From: alan.story@hertfordshire.gov.uk
Sent: 09 July 2019 14:05
To: Planning
Subject: Planning application 6/2018/3292/MAJ - Land adjacent to 45 Broadwater Road

Response to Planning application from Hertfordshire County Council (T and CP GDP Order 2015)

Land adjacent to 45 Broadwater Road
Welwyn Garden City
AL7 3AX

Erection of four-storey development comprising 91-bed care home with 13 care suites

drawing number **BPWELWYNGC.1/TK05** | rev. **A**

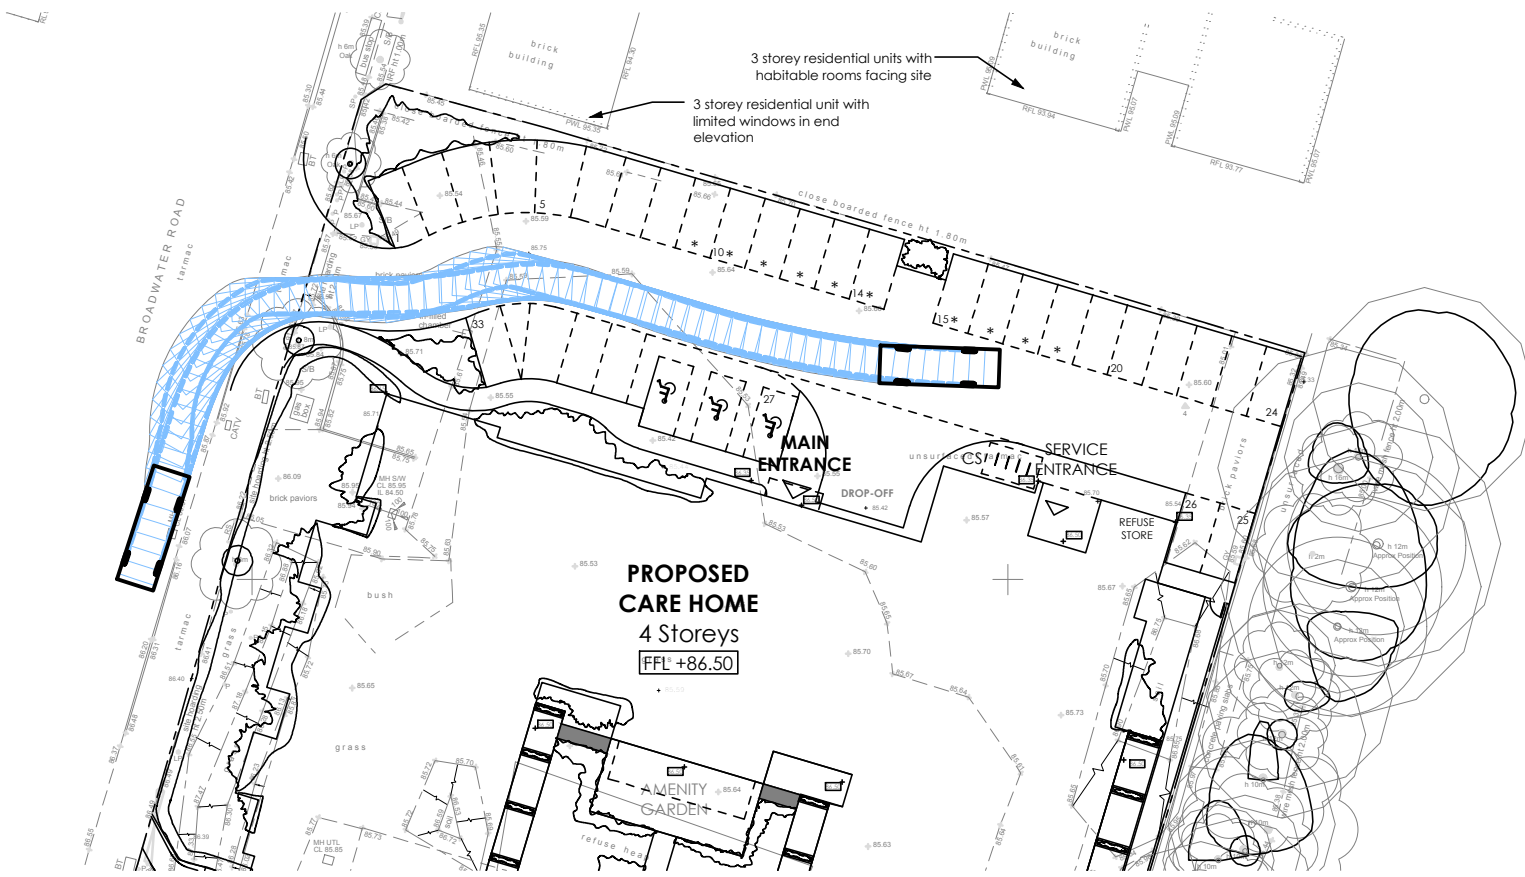
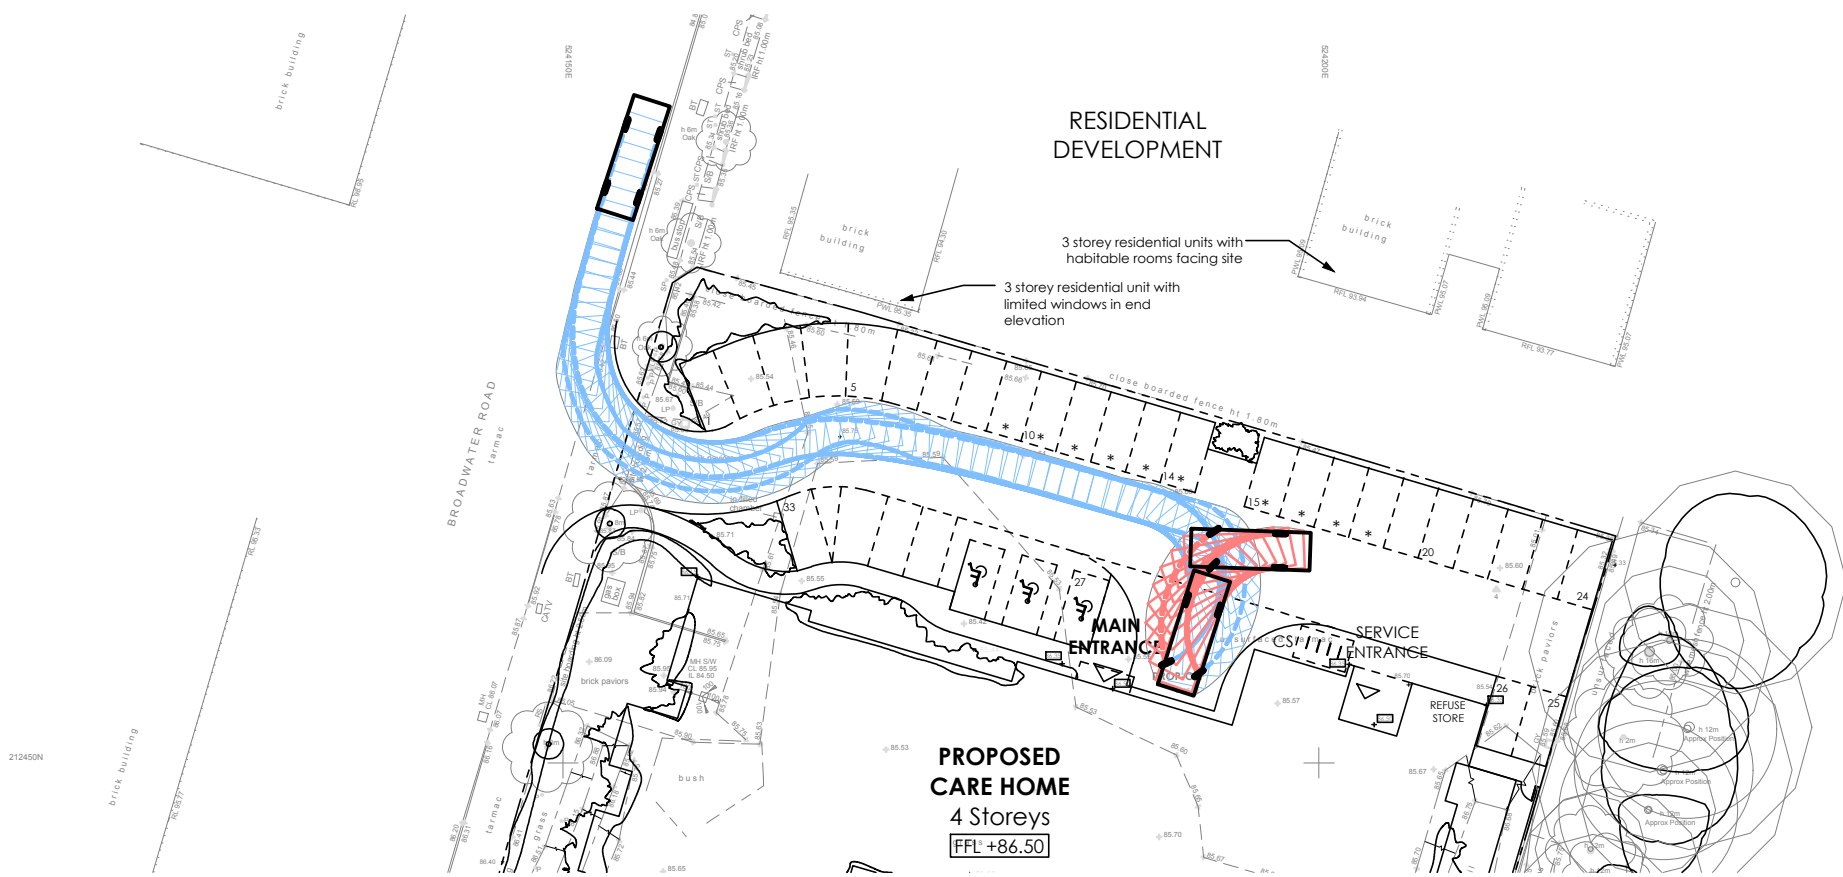
The Highway Authorities concern was that the application (drawing BPWELWYNGC.1/TK05 Rev A) provided swept path for refuse lorries (12.1m) but the ability for such vehicles to turn within the site required 10 parking spaces to be empty (such spaces all adjacent to each other). Such level of parking represented one third of all parking within the site.

Further, the Technical Note has undertaken swept path analysis for vehicles employed by WHBC. Such vehicles are shorter than recommended by the HA in terms of undertaking swept path assessment, as use of shorter vehicles based on current stock, does not future proof development for a time that change of contracts / vehicle fleet might result in larger vehicles. Notwithstanding this observation, the revised tracking demonstrates loss of parking (temporary) as 8 spaces.
